Submissions Report for
Concept Plan Approval
(Residential, Commercial / Tourist Development and
Environmental Works); and

Project Application Approval
(Stage 1 'Environmental Works')

Lot 1 DP 374315, Lot 4 DP 615261 and
Part Crown Reserves (R82555 and R754444),
Ocean Drive, Lake Cathie

Application No. MP07_0010

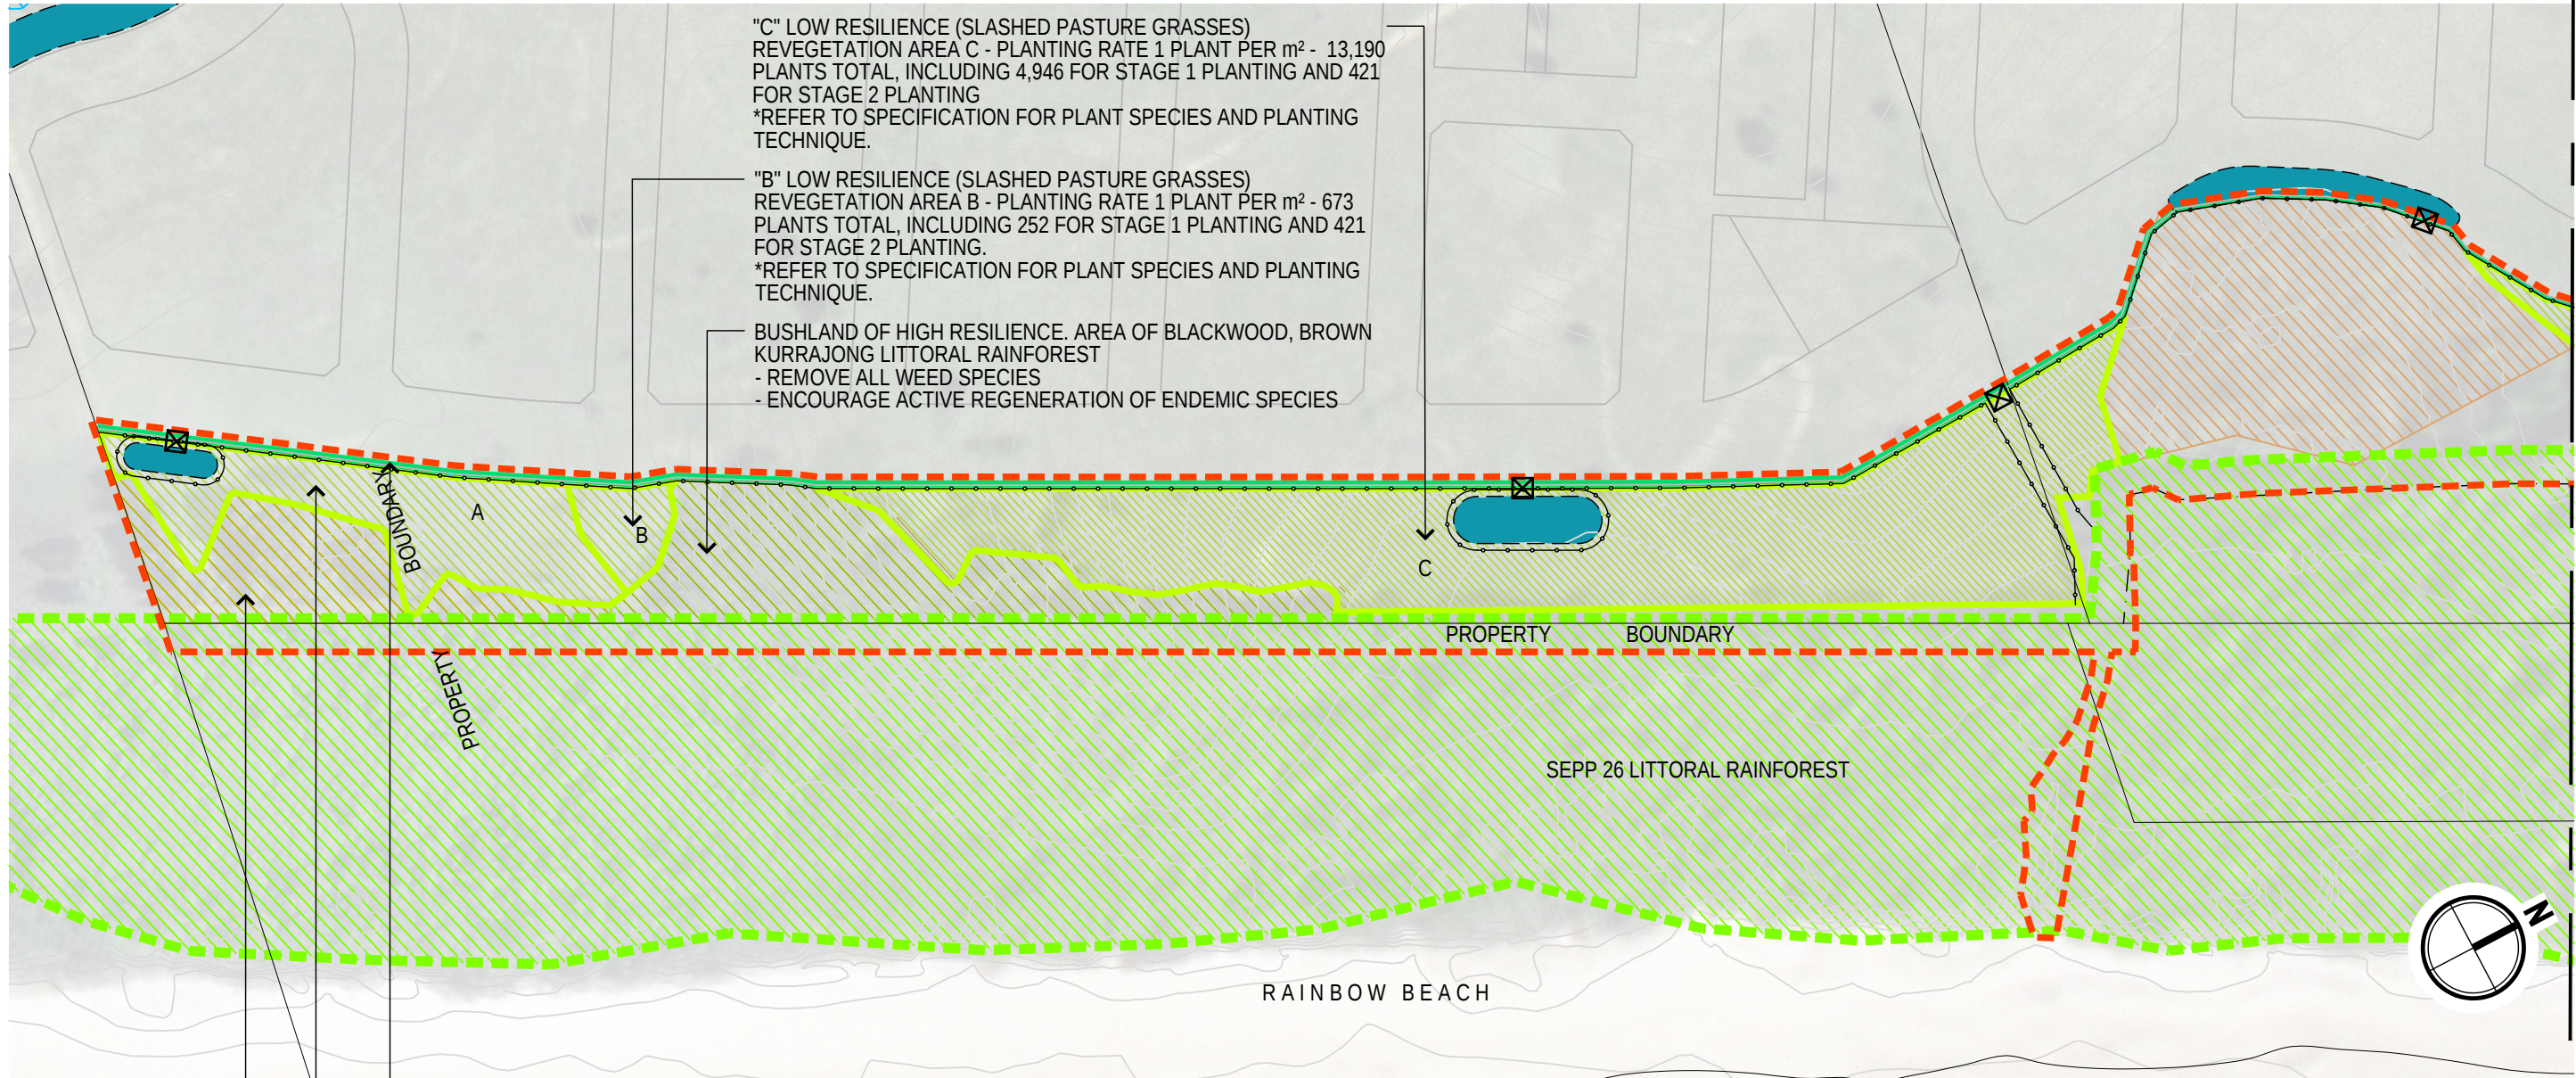
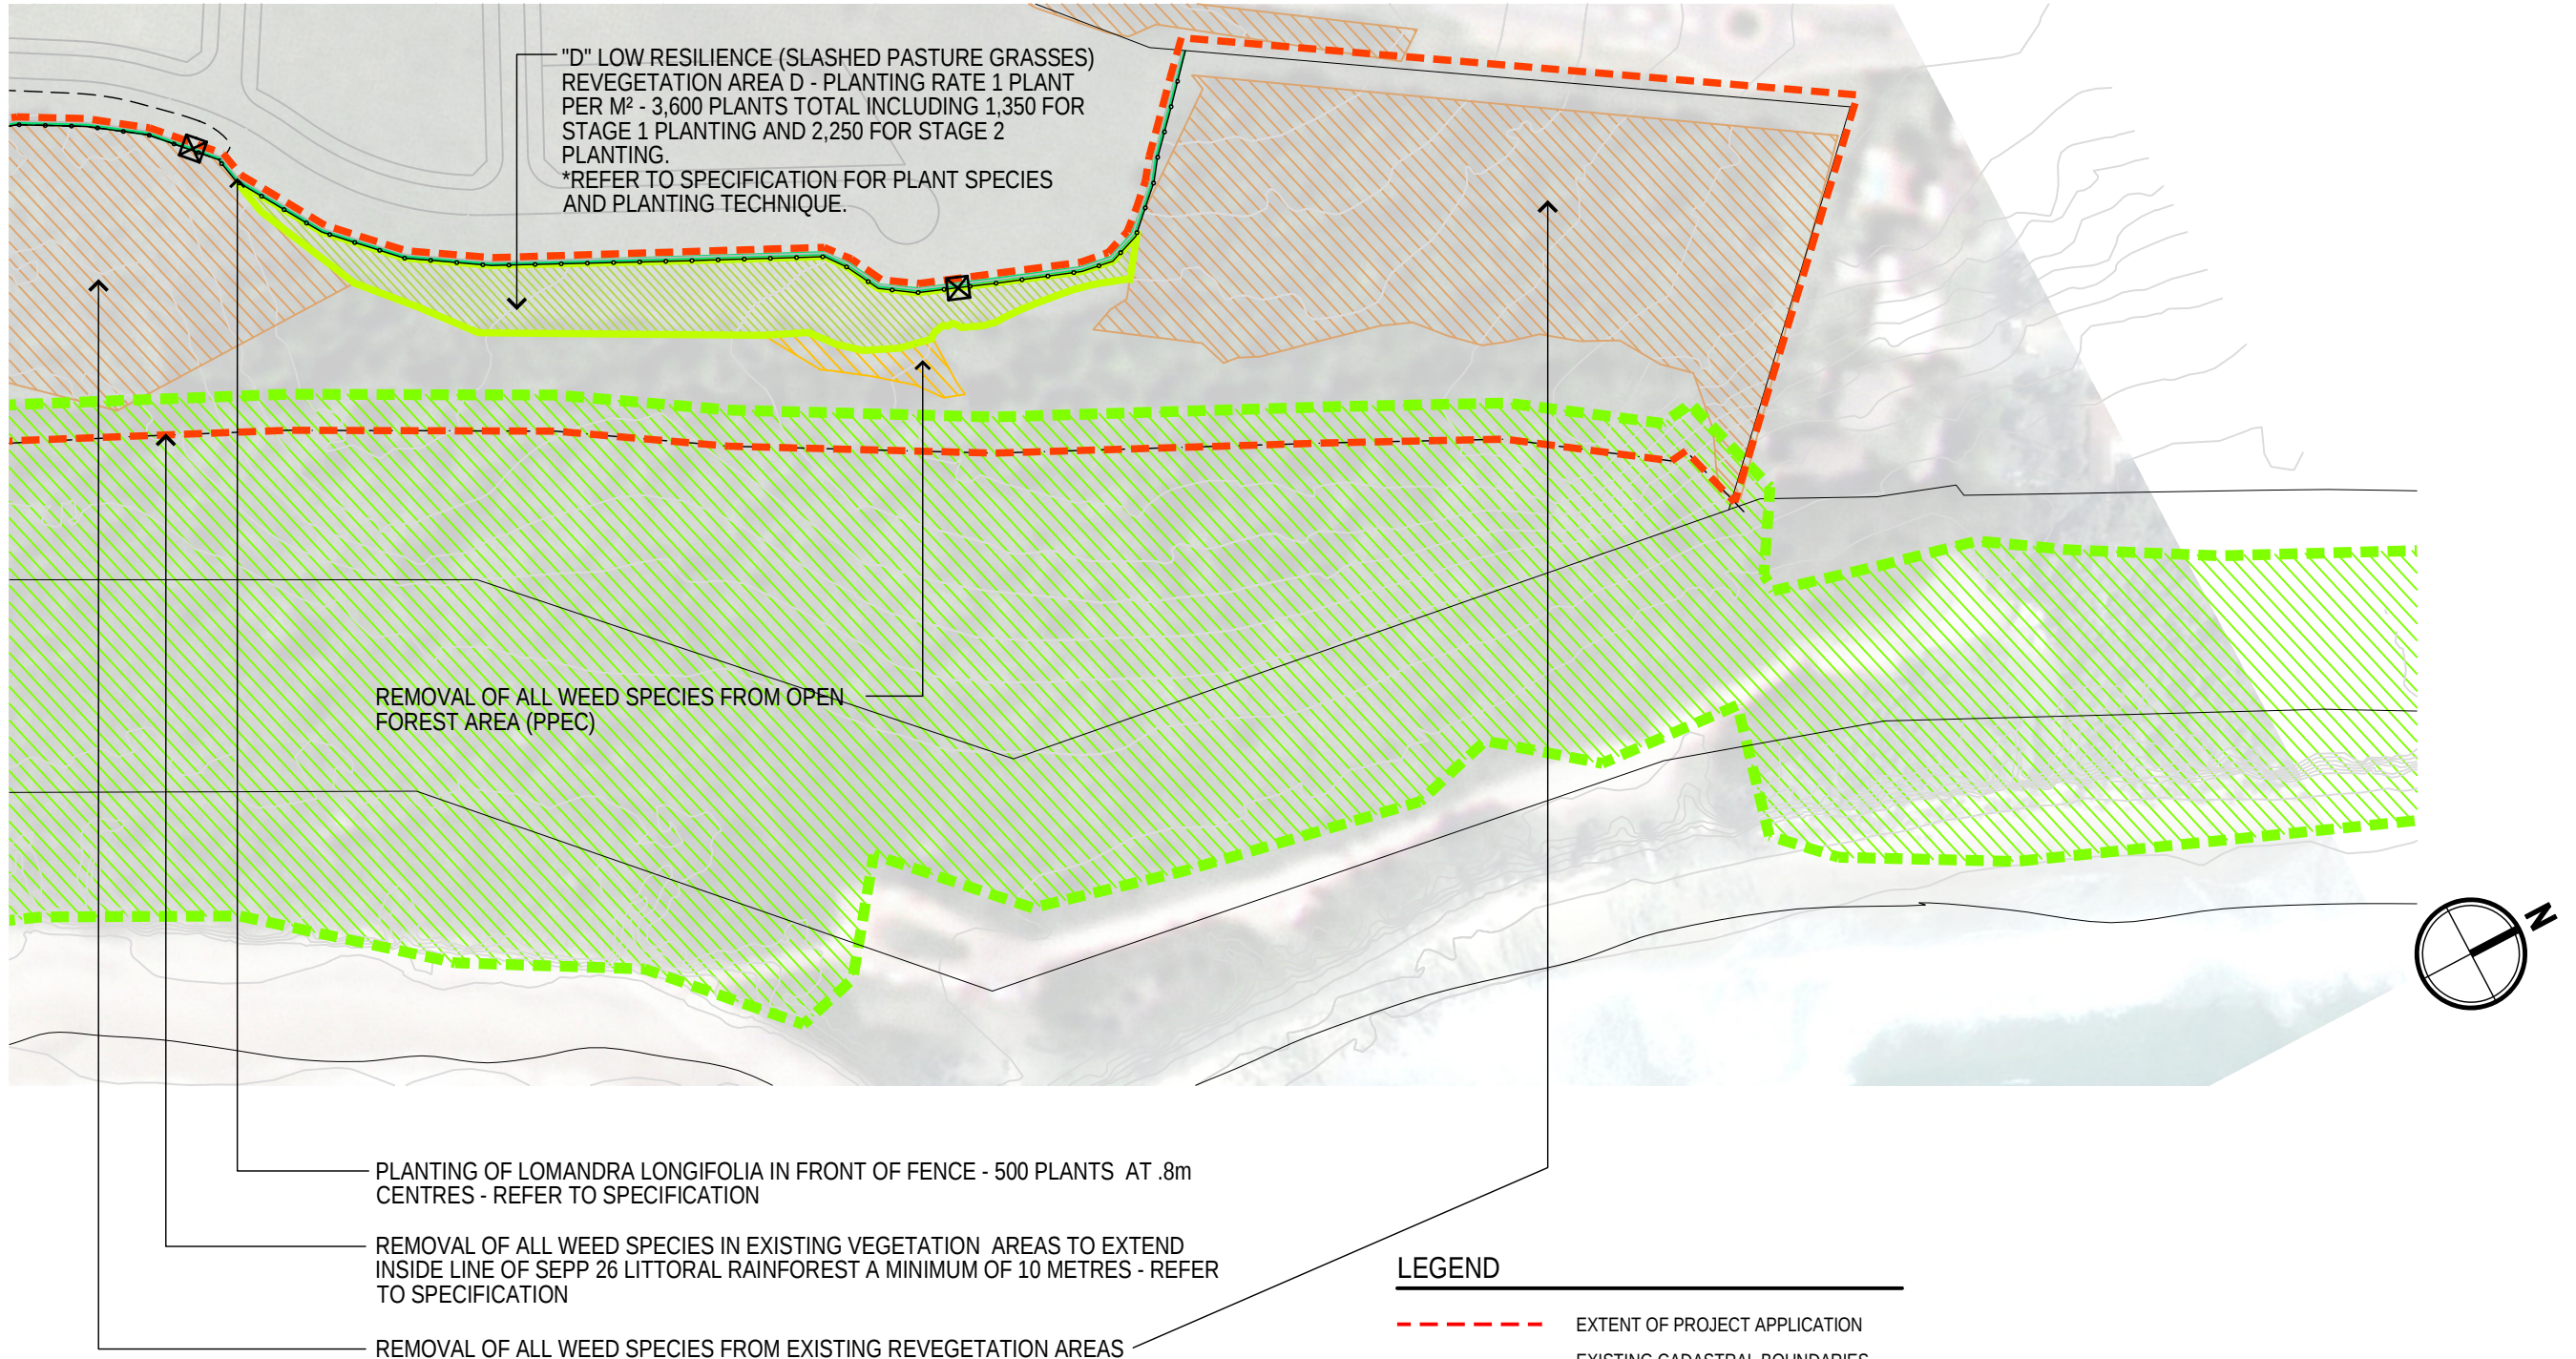
No.	Author	Issues / Requirements	Comments
		<p>e. VMP should be extended to include all of rainforest adjacent to Lot A (Lot 1) and all of rainforest within Lot 4 and the provision of a 30m buffer to Duchess Creek;</p> <p>f. Recommends following conditions for VMP:</p> <ul style="list-style-type: none"> i. Commence all rehabilitation works at the initiation of the VMP – table of defined work zones is to include rehabilitation works, staging and completion dates; ii. Contingency/ follow up plan for failed plantings and poor response of weed control; iii. 6 monthly weed inspection schedule; iv. Signage to direct people to public access 	<p>consultation between the bush regenerators contracted to do the work and PMHC prior to undertaking any work.</p> <p>The '<i>extent of Concept Plan</i>' and '<i>extent of Project Application</i>' boundaries have been revised on all exhibits such that the Littoral Rainforest currently within private ownership (i.e. Lot 4) is included. In so doing, the area the subject of the VMP is now also included. The notation on sheet 2 of Exhibit PA 05 (prepared in support of the VMP) has been revised to ensure that weed removal occurs within the rainforest area located on Lot 4.</p> <p>In relation to the rainforest within the crown land adjoining Lot A (Lot 1), the VMP notes at section 6.1.2.6 of the EA that this area is currently undergoing regeneration / weeding works by the Bonny Hills Landcare Group and so suggest there is currently no need to extend the VMP to include this land .</p> <p>The rehabilitation and revegetation of the buffer area to Duchess Creek along with the additional revegetation work between the exclusion fence and the pathway/cycleway will be undertaken as part of the 2nd stage development, as shown on Exhibit 05B_Indicative Staging Plan. A revision to the Statement of Commitments (CP18) will require the preparation of a VMP as part of this stage.</p> <p>The VMP at Section 6 to the EA was prepared in close consultation with Ms Sue Regan of Wildthings Native Gardens. Ms Regan has been a bush regeneration contractor since 1996. The VMP is particularly detailed in relation to weed eradication, plant establishment and ongoing maintenance. The VMP of the EA is supported by Exhibits PA05 (2 sheets), the Base Line Weed Map at Exhibit PA04, the Gantt Chart at Appendix PA_A and the Photographic Record Sheet at Appendix PA_B. It is the intent of the VMP that the works be initiated immediately and accordingly, the VMP represents the majority of works within the Stage 1 Project Application.</p> <p>The identification and carrying out of this first stage is seen as critical to the overall development of the site. The Stage 1 Environmental Works will result in the immediate protection and enhancement of the rainforest and when</p>

PA05, rev D, sheet 2,	Vegetation Management Plan	PA05, rev E, sheet 1	As above – revision to extent of Concept Plan Application to coincide with boundary of Lot 4, weed removal notation amended and ground ruffling notation added.

Boardwalk using Replas Enduroplank™

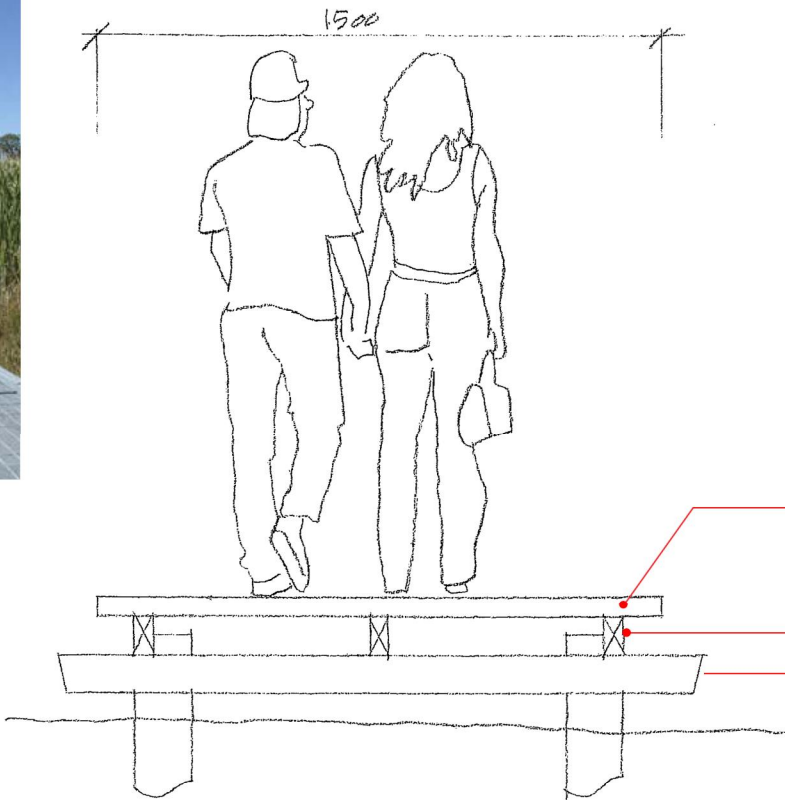
No.	Author	Issues / Requirements	Comments
		<p>b. Boardwalk to be confined to existing 2.2m wide track;</p>	<p>The buffer width issue is discussed at length at Section 5.1.1 to this report. We confirm that the content and width of the buffer has been developed over a number of years (since 2002) and in consultation with a number of specialists, PMHC and the Department of Planning. The preliminary investigations identified groundwater as a key issue for the ongoing preservation of the rainforest. Accordingly, PMHC commissioned ecological (Biolink) and groundwater (Martens) investigations to determine both the current and future water needs of the Littoral Rainforest, given the future adjoining urban development and expected changes in rainfall as a result of climate change. The ecological and groundwater investigations support that a vegetated buffer of between 40m – 60m, with specific stormwater management recommendations, is the most appropriate width to achieve this. The perimeter road, parking bays, cycleway and pedestrian pathway comprise the built form component of the buffer, ensuring a clear separation of public and private lands and allowing clear surveillance of the edge to the vegetation.</p> <p>Section 5.1.1 also provides a timeline of the agreed outcomes between the proponent, Council and the DOP, a summary and discussion of the specialist consultant requirements and where departures from their advice have occurred to reinforce the buffer treatment and confirmation in relation to compliance with the conditions of the Gateway Determination for the Area 14 Stage 1B zoning.</p> <p>Section 5.1.1 also confirms the support of PMHC for the buffer design as presented in the EA, as detailed in their report to the Council meeting of 16 February, 2011, in relation to the Planning Proposal for Area 14 Stage 1B and forwarded to DoP to make the LEP.</p> <p>The proposed 1.5m wide boardwalk is to be positioned within the existing 2.2m wide informal walking track. The location and width of this existing track has been confirmed by survey. Requirements in relation to this issue are included in the SOC.</p>

EA Exhibit number	EA Exhibit description	Revised Exhibit number	Description of Revision
PA06, rev A, sheet 1	Rainforest Boardwalk	PA06, rev B, sheet 1	Revisions to design and finish of the boardwalk have been incorporated on the plan, as set out at commitment number PA09.
PA06, rev A, sheet 2	Rainforest Boardwalk	PA06, rev A, sheet 2	No revisions.
